FINAL PLAT

CITIZEN ON CONSTITUTION FILING No. 1
A REPLAT OF TRACTS M & N, URBAN COLLECTION AT PALMER VILLAGE
A PORTION OF THE NORTHEAST QUARTER OF
SECTION 5, TOWNSHIP 14 SOUTH, RANGE 65 WEST OF THE 6TH P.M.
COUNTY OF EL PASO, STATE OF COLORADO

AS PLATTED

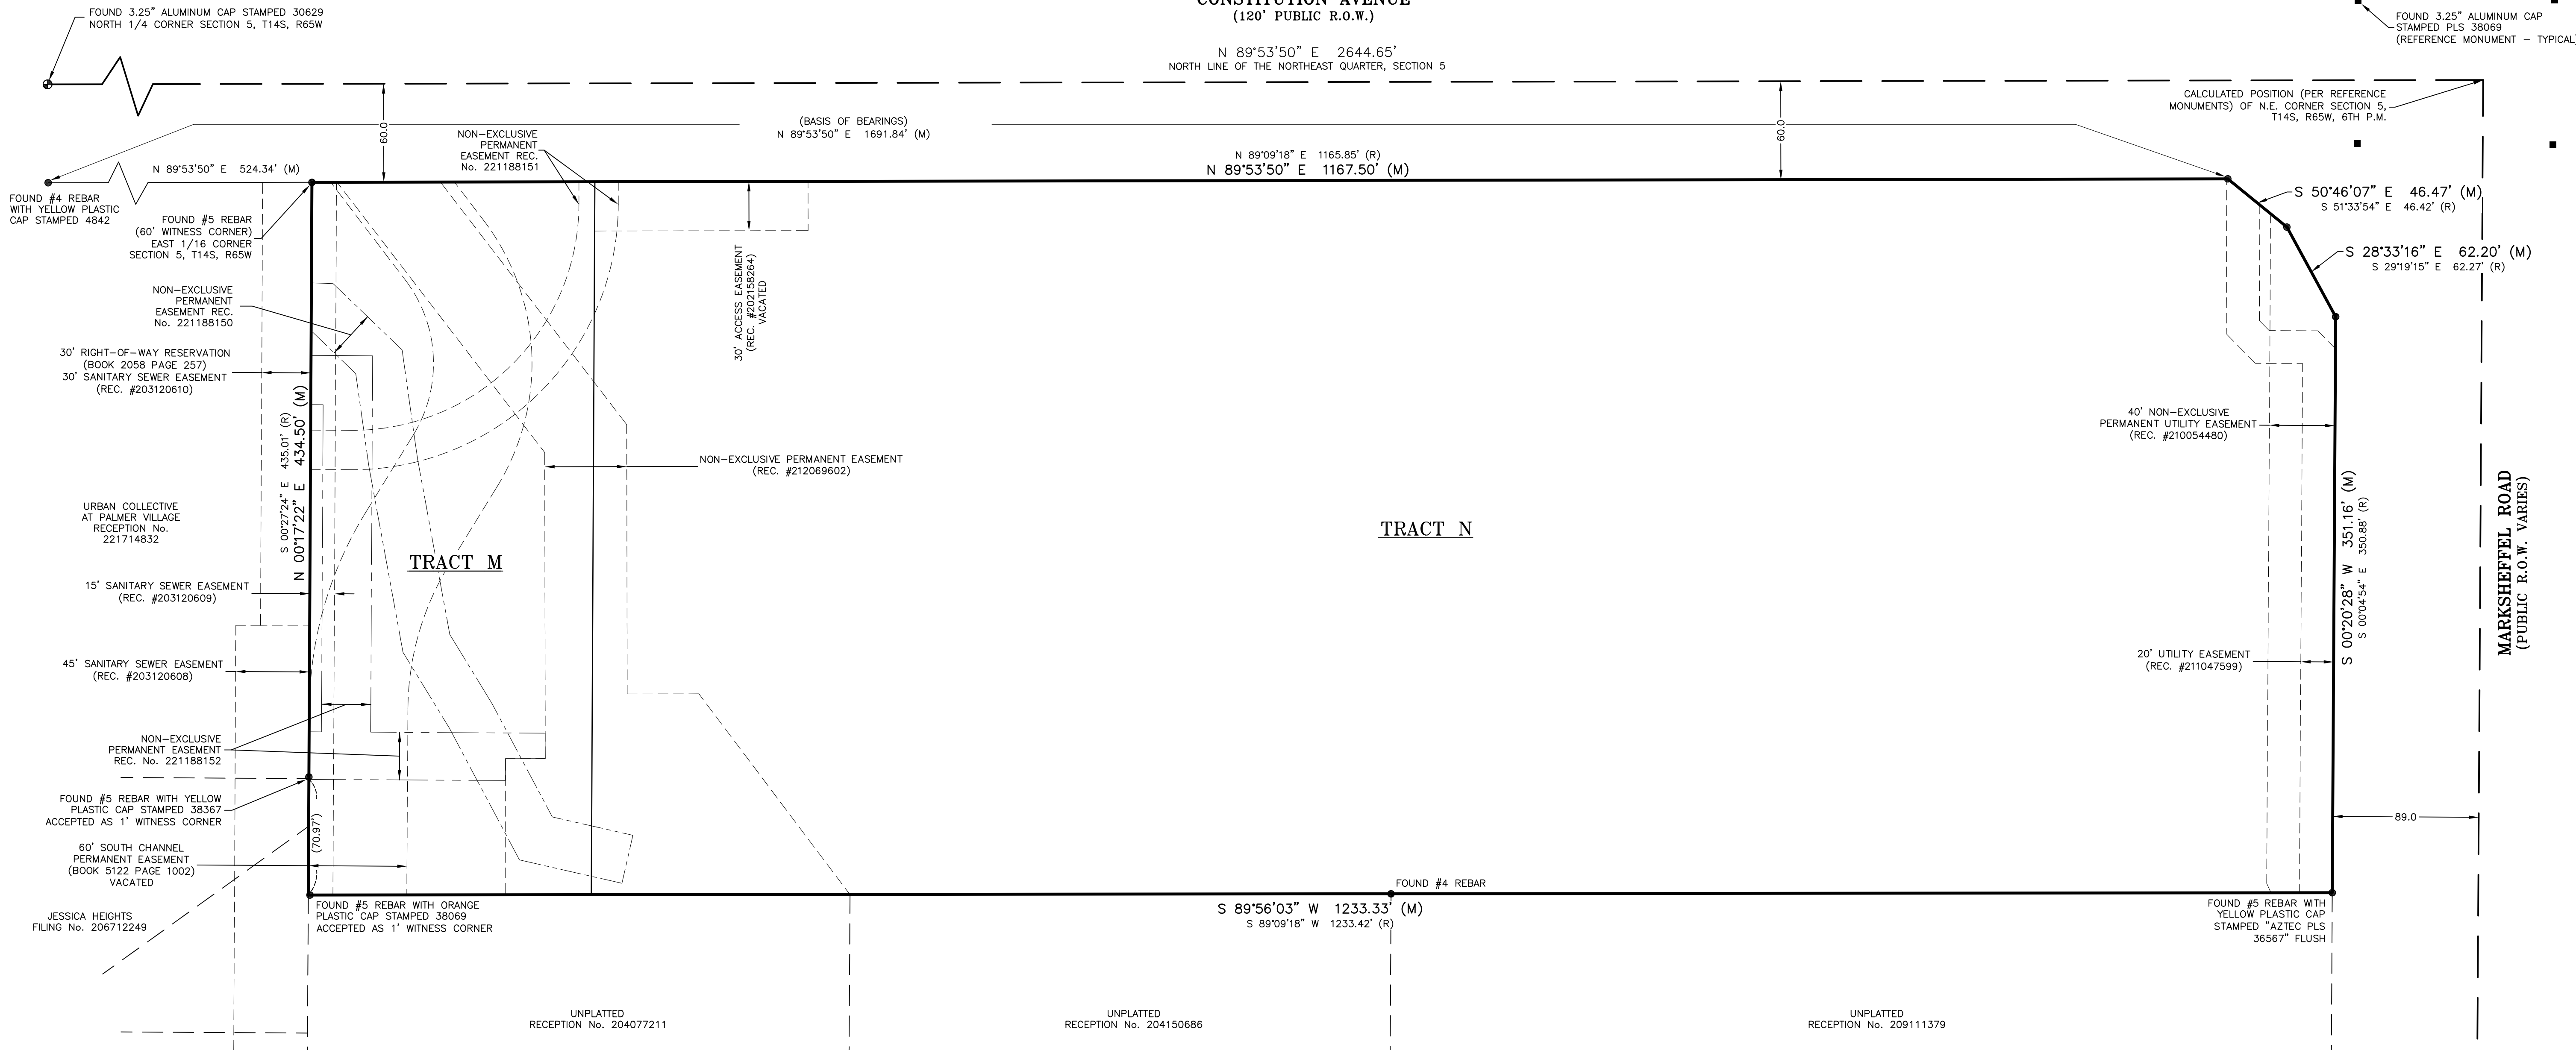
Minimum easement width provided for gas-only service (20'). No other conflicts other than LBS comment. smanning 2/22/22.
